PCD-ENGINEERING REVIEW COMMENTS
IN BLUE BOXES WITH BLUE TEXT

STORMWATER MANAGEMENT PLAN

FALCON MEADOWS AT BENT GRASS DRAINAGE CHANNEL IMPROVEMENTS

PCD FILING NO.:  CDR2114

G1.0

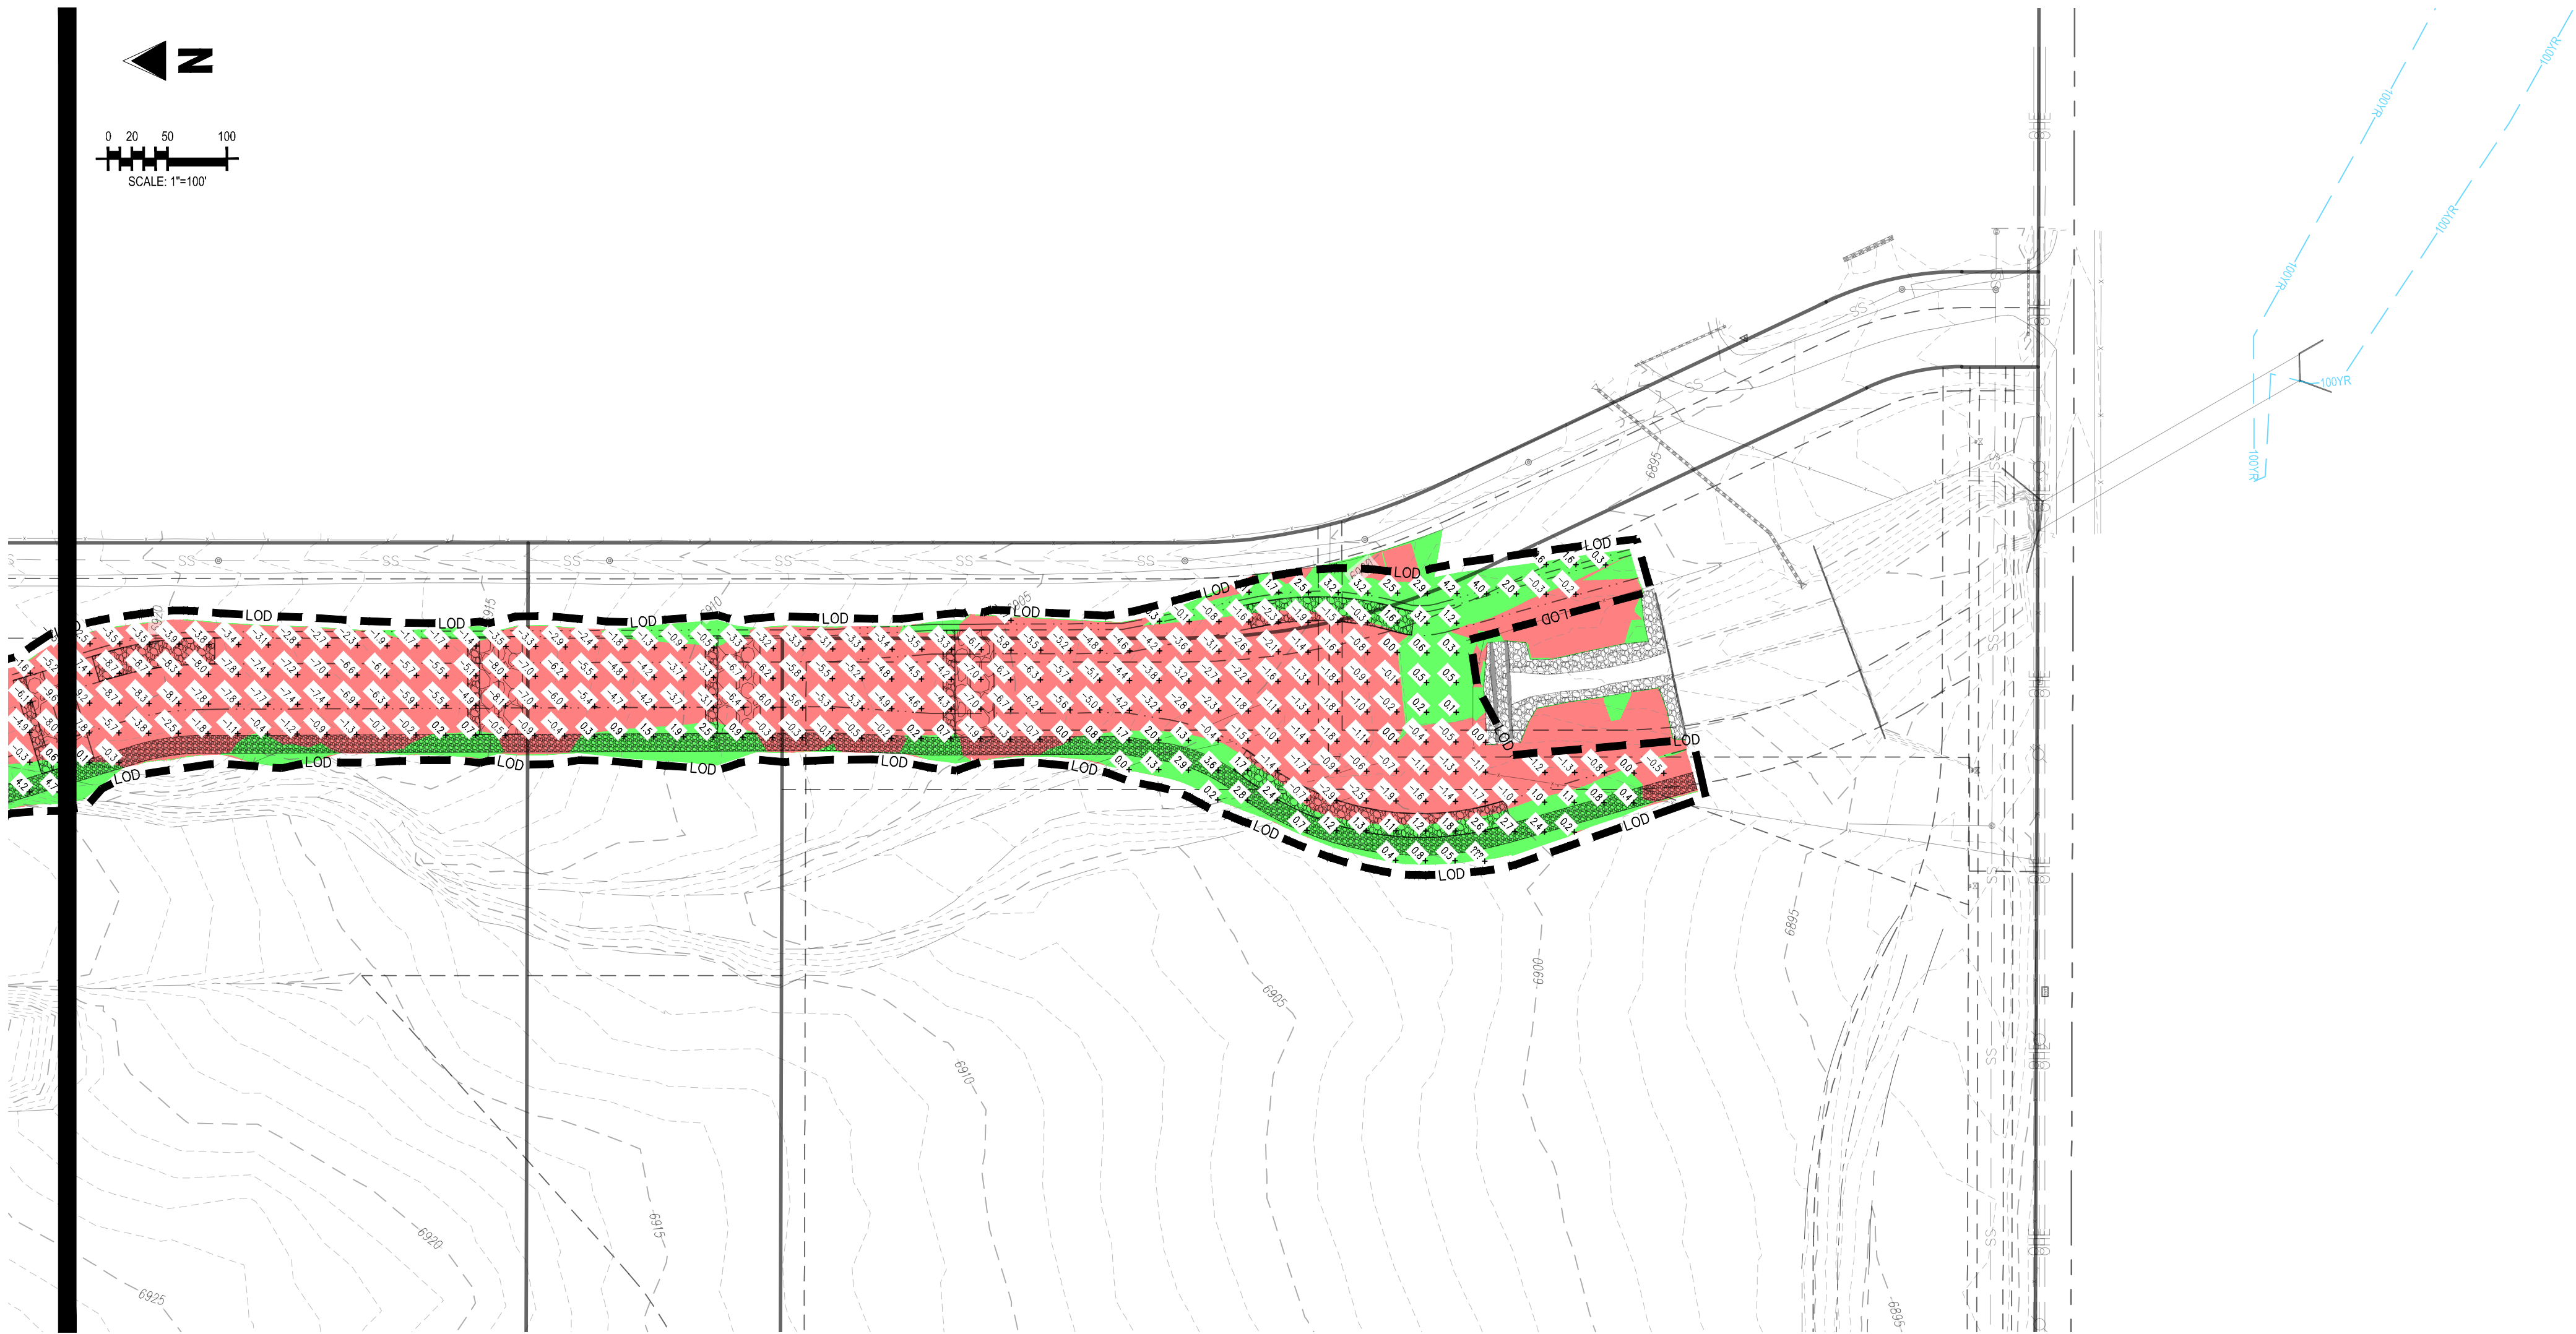
please provide current best estimates
